FINAL SITE GRADING CONSTRUCTION PLANS
FOR
CREEKSIDE SOUTH AT LORSON RANCH FILING NO. 1
FINAL GRADING / EROSION CONTROL PLANS

PROJECT:
CREEKSIDE SOUTH AT
LORSON RANCH FIL. 1
TRAPPE DR. HORTON DR.
COLORADO SPRINGS, COLORADO

FINAL GRADING AND
EROSION CONTROL PLAN

DATE: MAY 12, 2020
 PROJECT NO: 100.051
 SHEET NUMBER: C4.1
 TOTAL SHEETS: 15

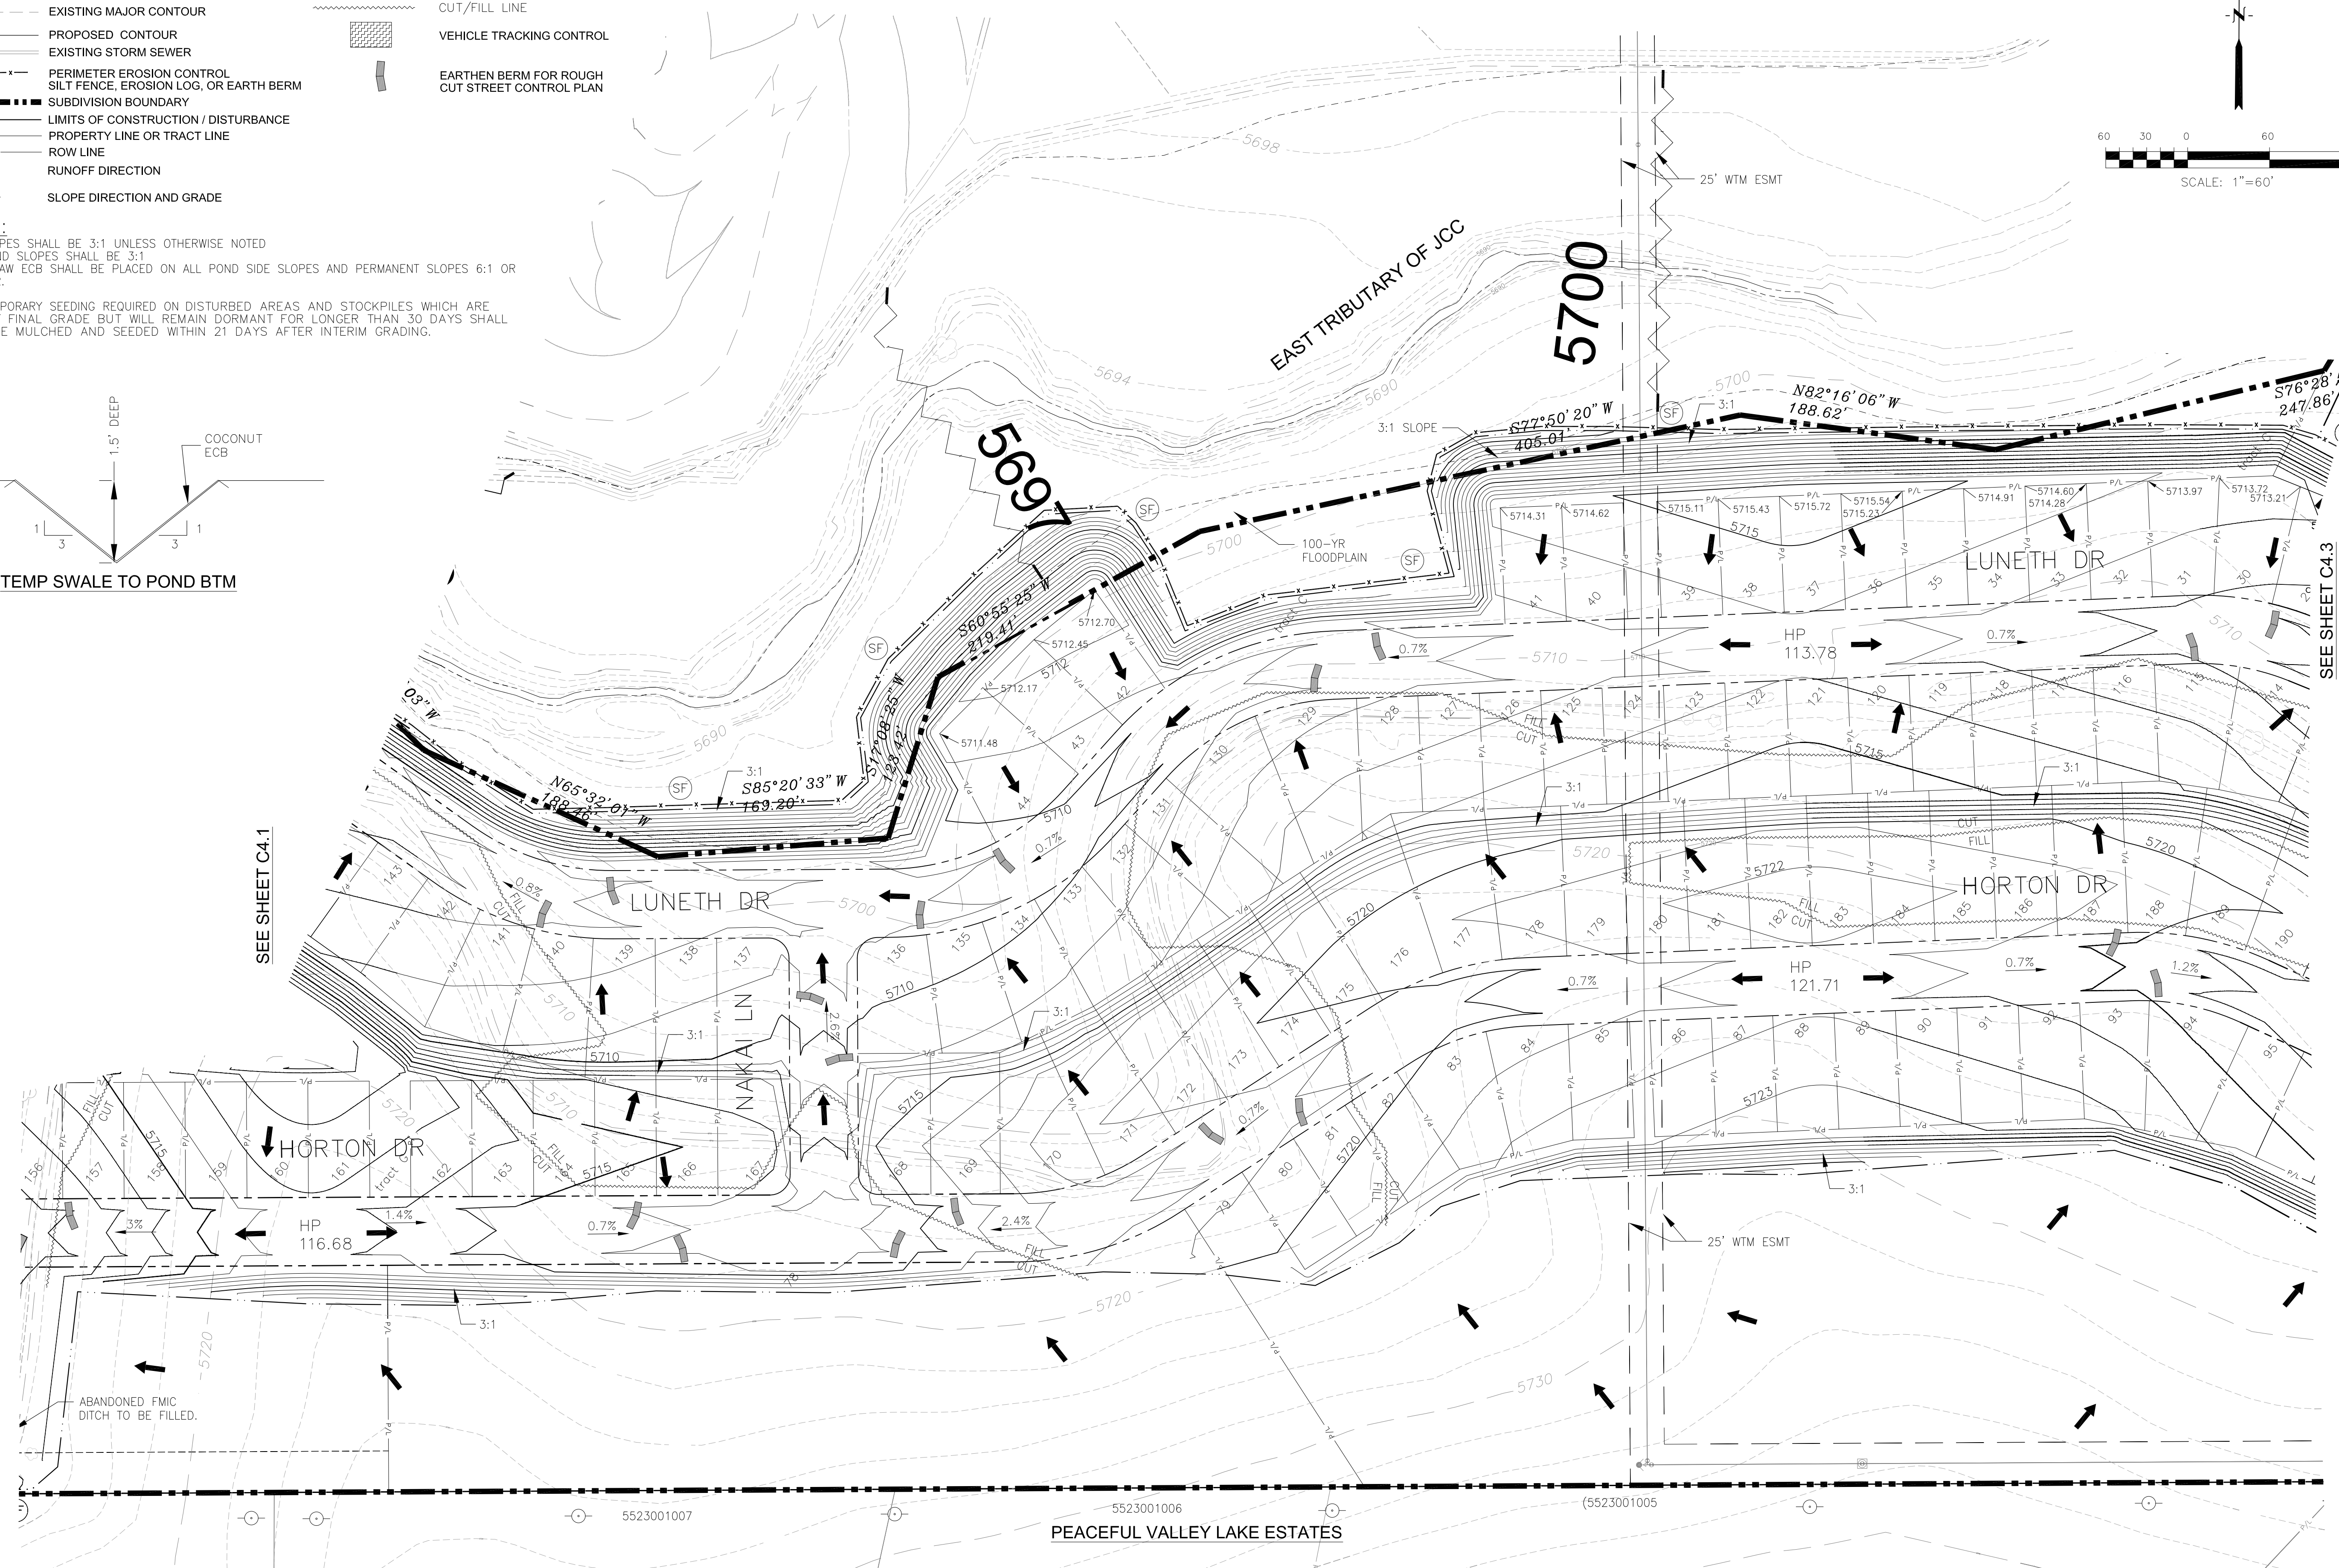
This note is ok per the DCM, but does not match what is in SWMP section 5.3 and 5.4

Consider adding rock socks, check dams, or J-hooks with silt fence along the silt fence that runs perpendicular to contours.

Item CC - label drainage easement shown in Plat

Need a pond access easement around the pond, which isn't shown on Plat either.

Show more outlet protection here than just SF.

**CREEKSIDE SOUTH AT LORSON RANCH
 OVERLOT EARLY GRADING AND
 EROSION CONTROL PLAN**

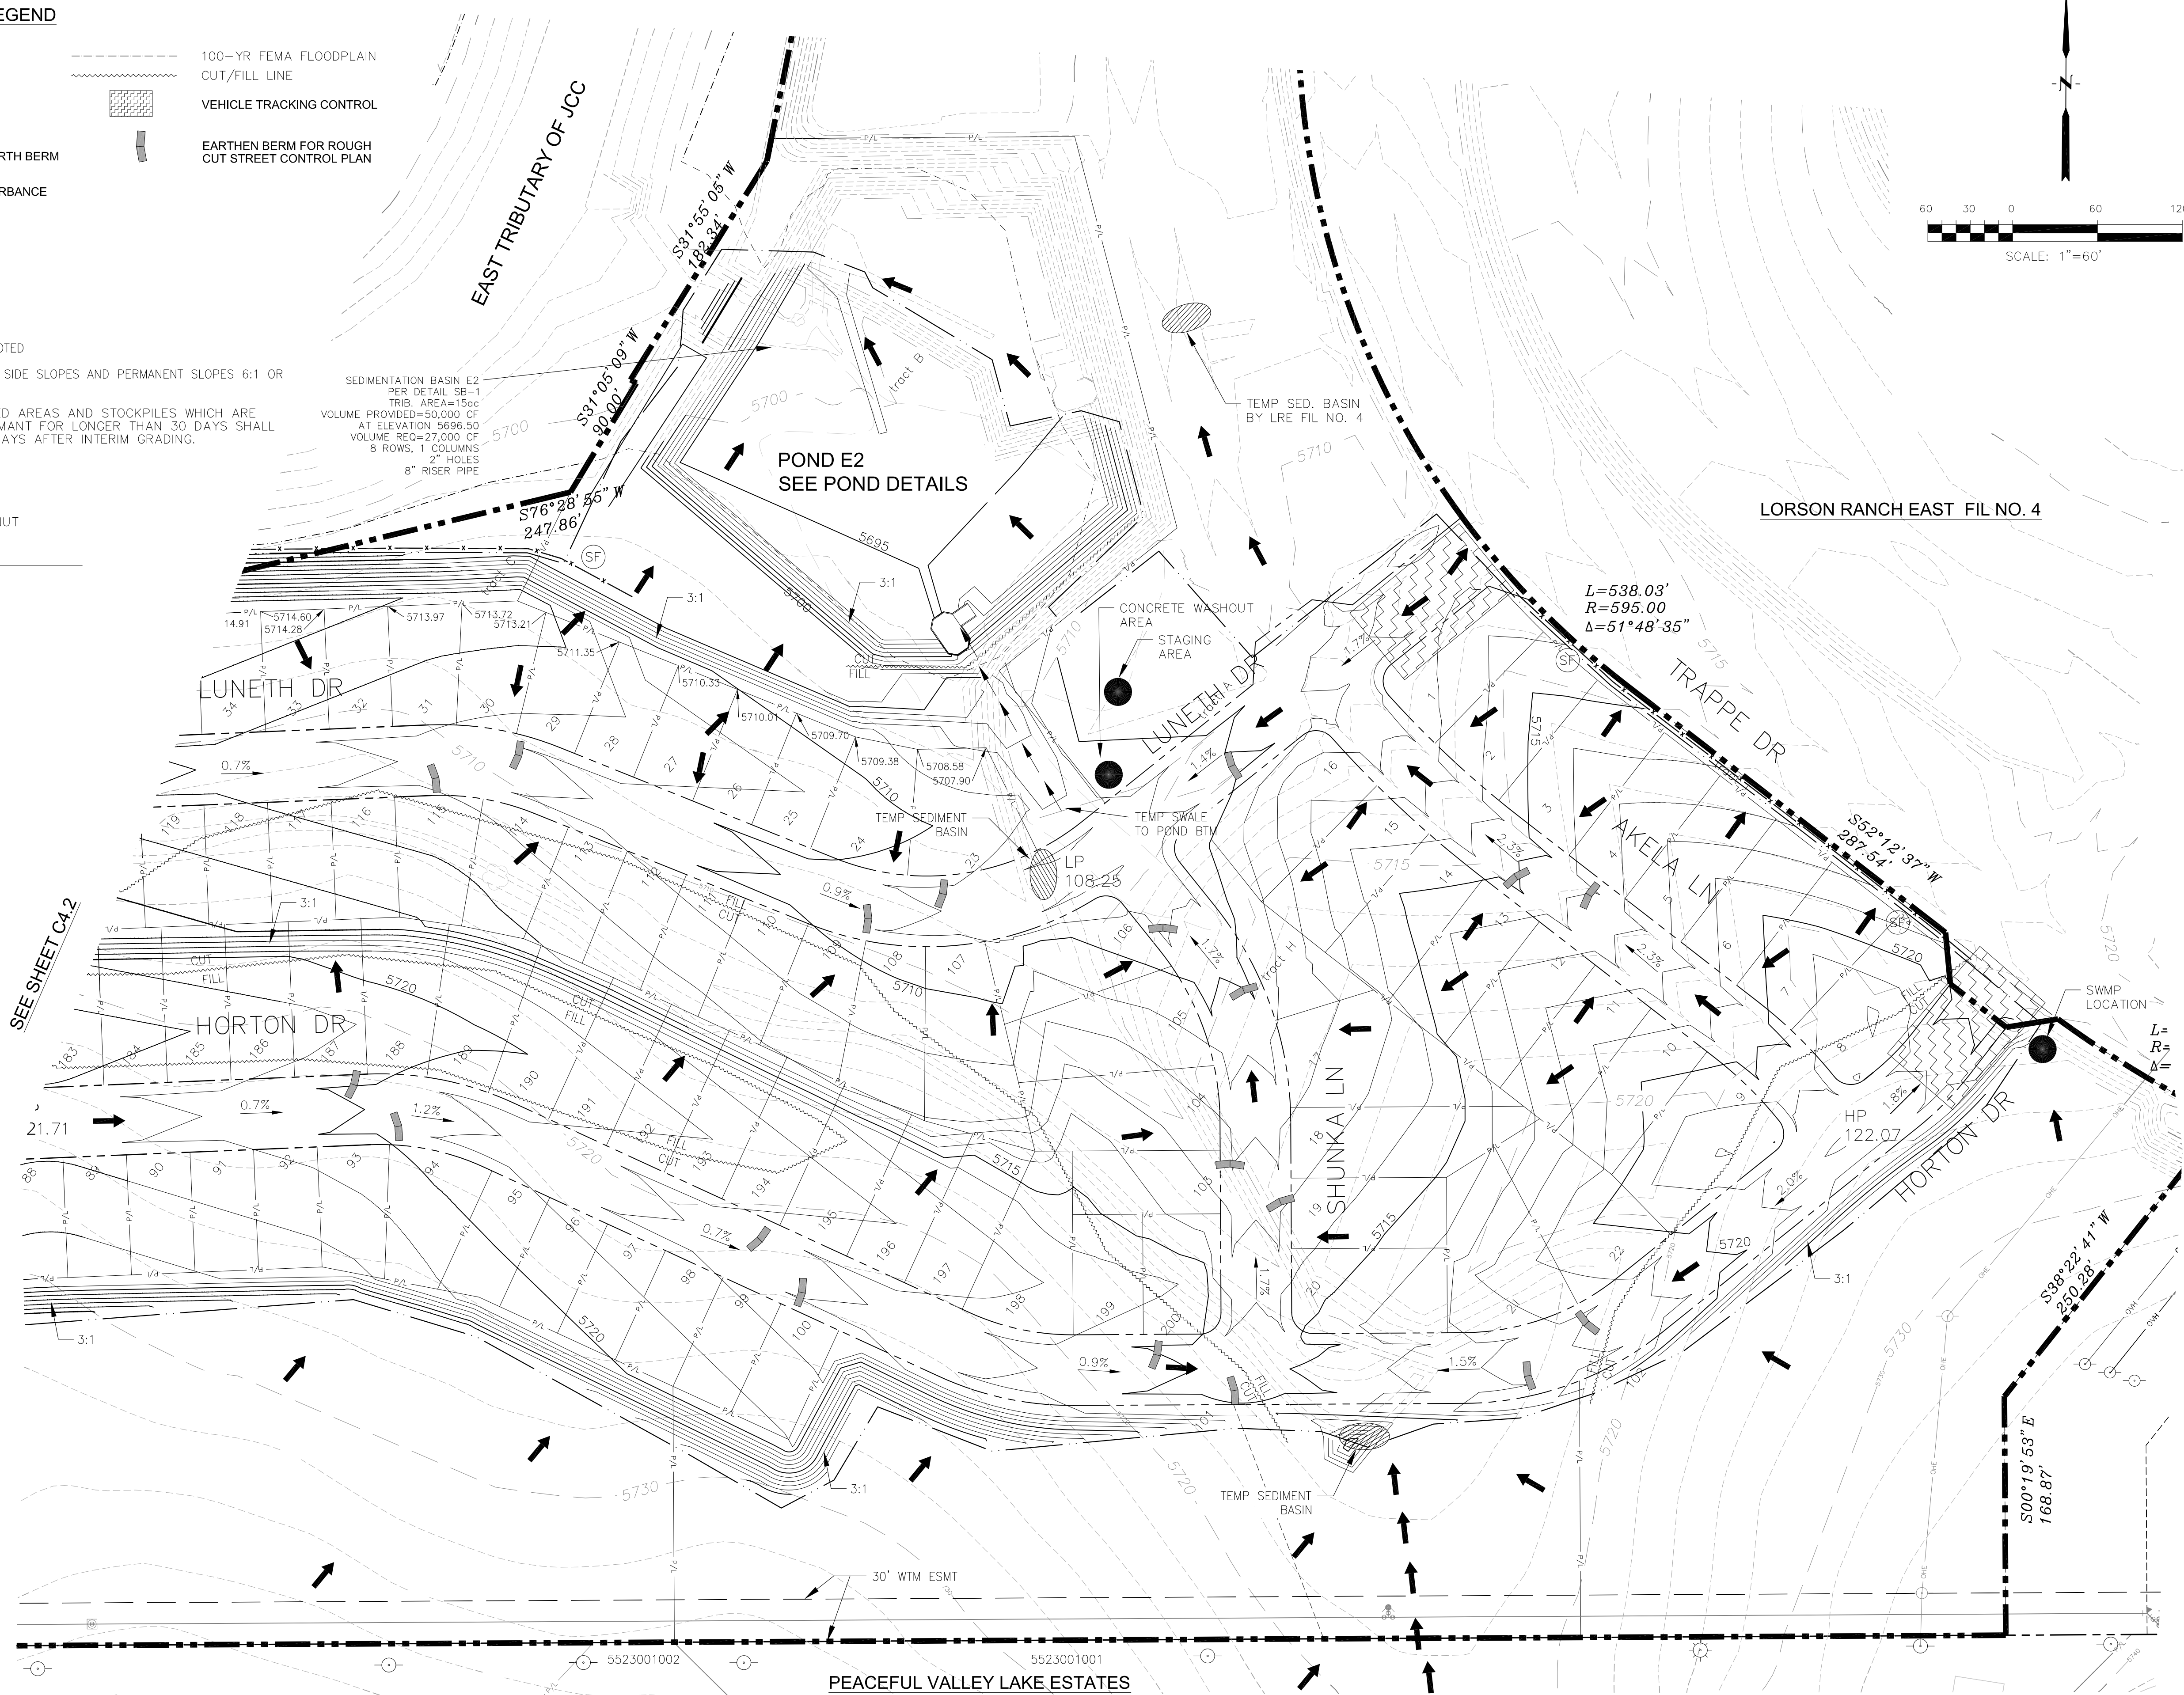
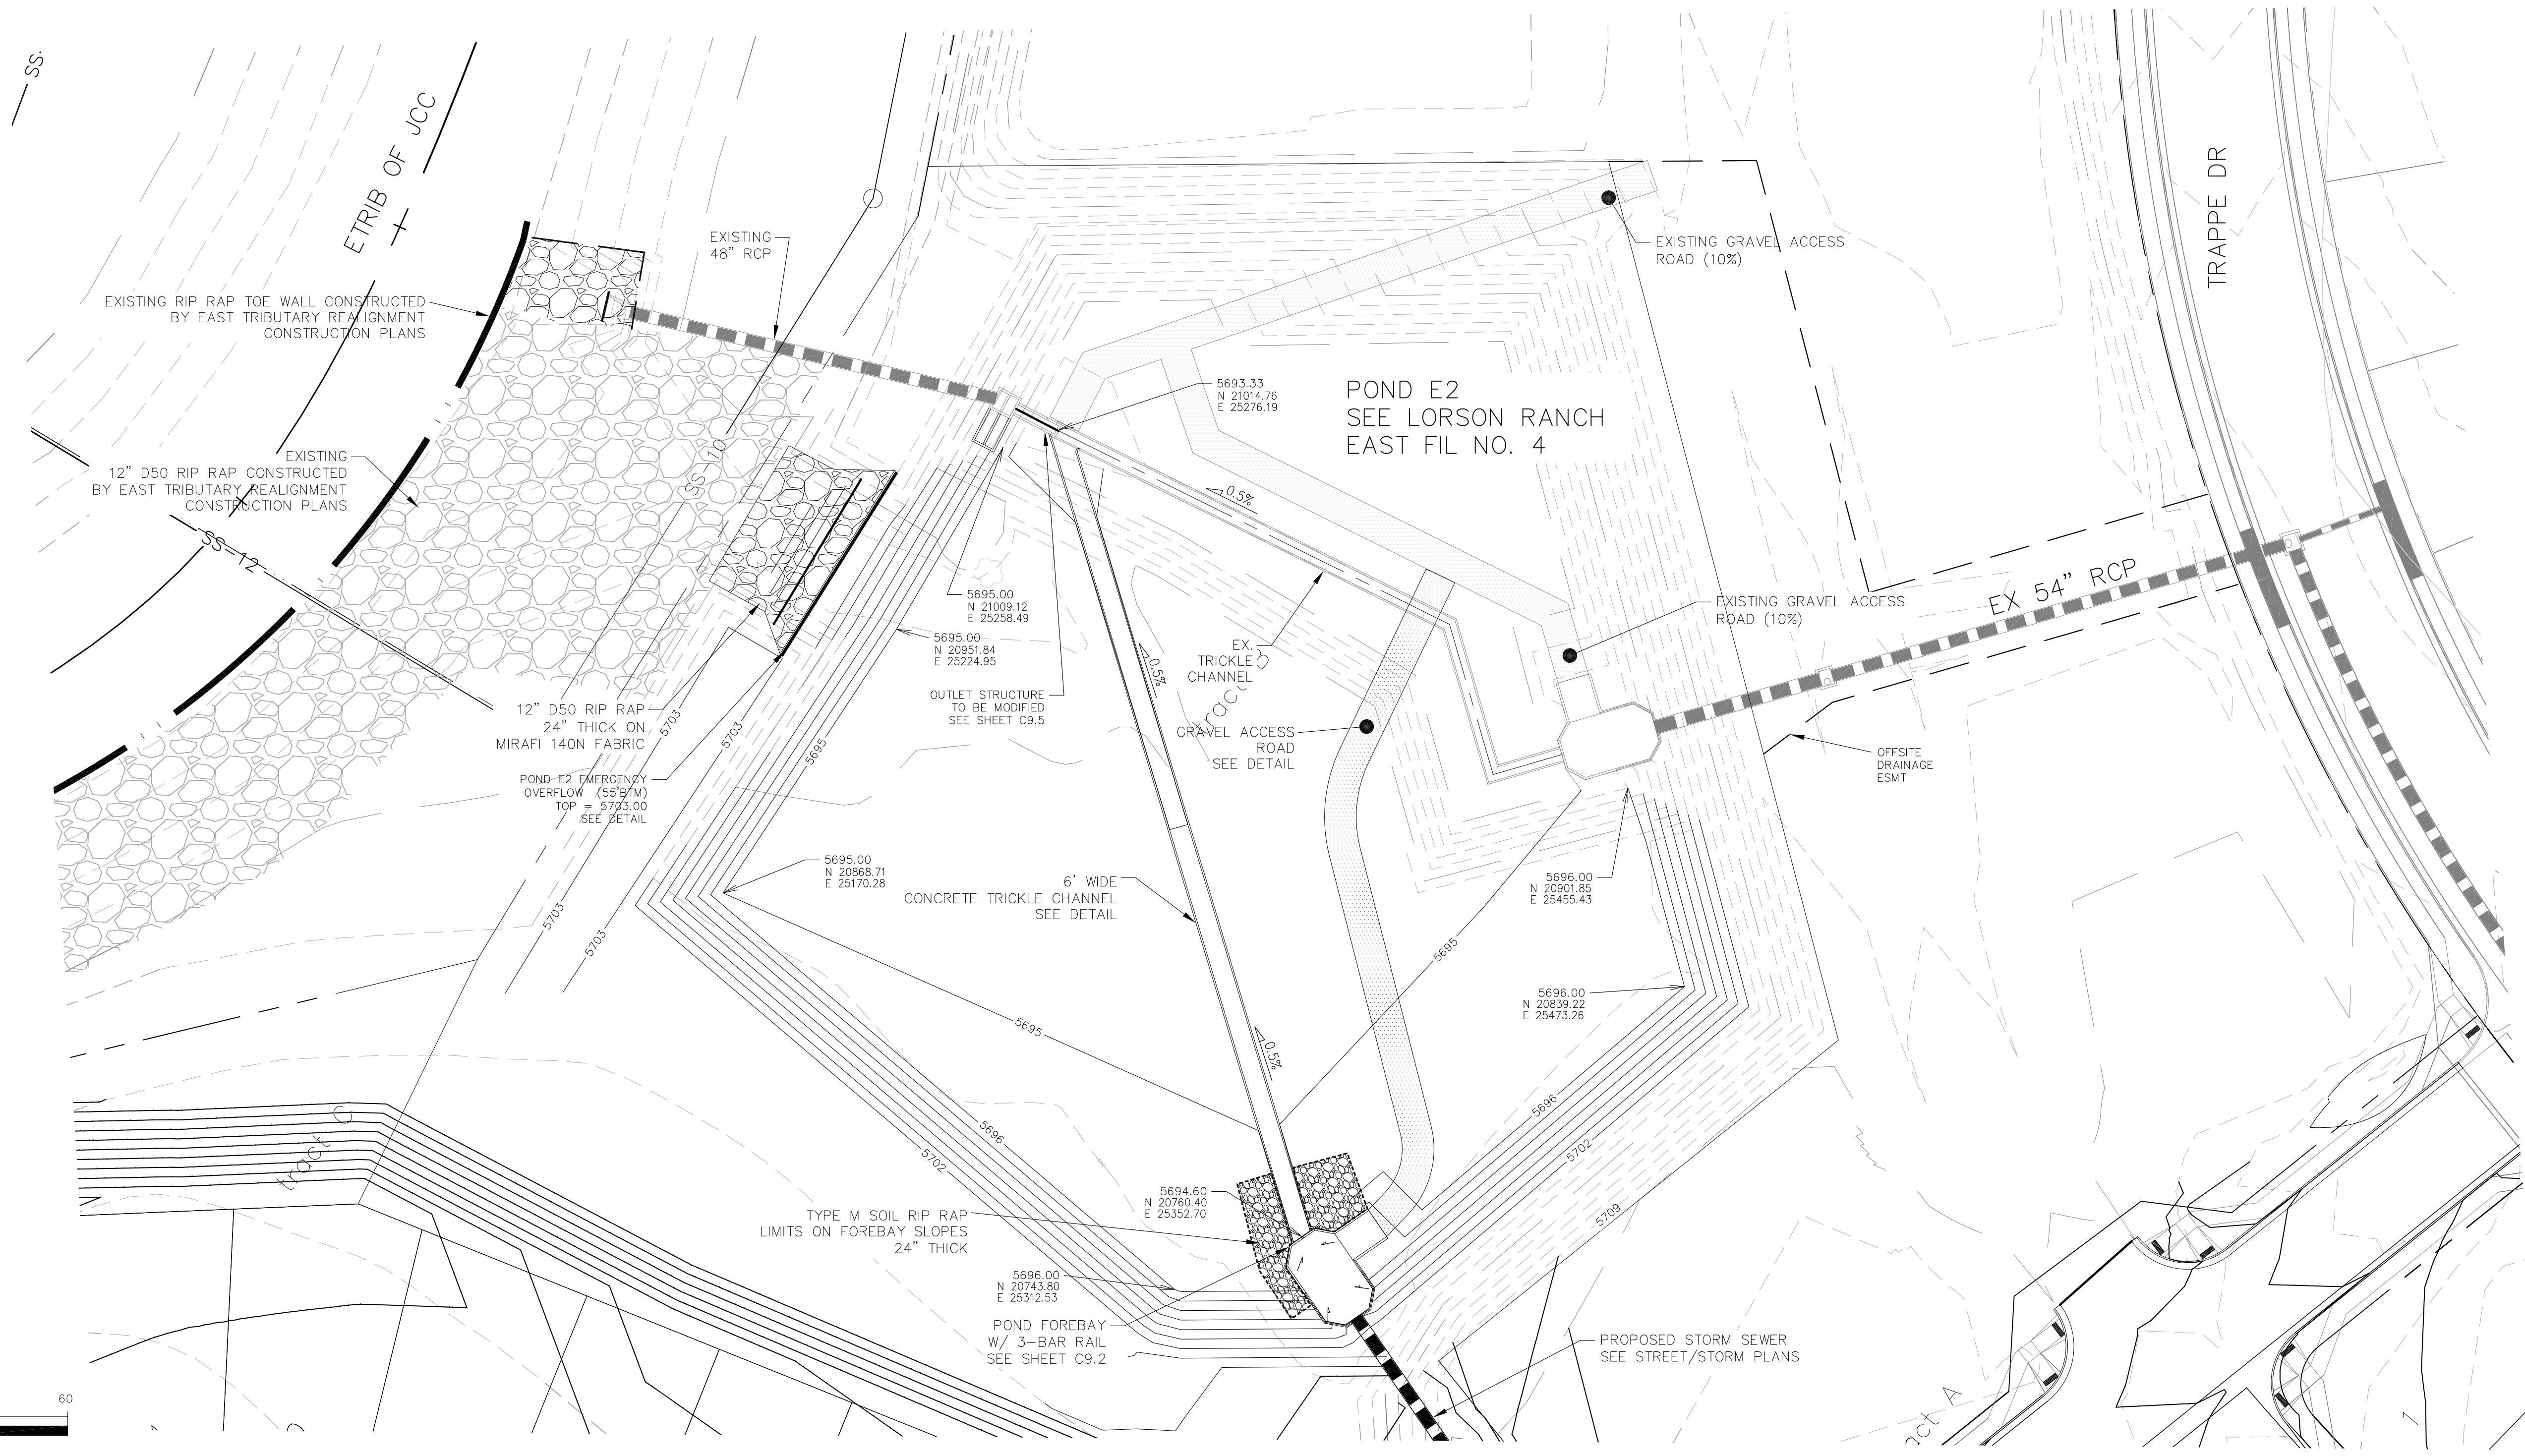
include these 2 items
in the legends on
Sheets C4.1 to C4.3
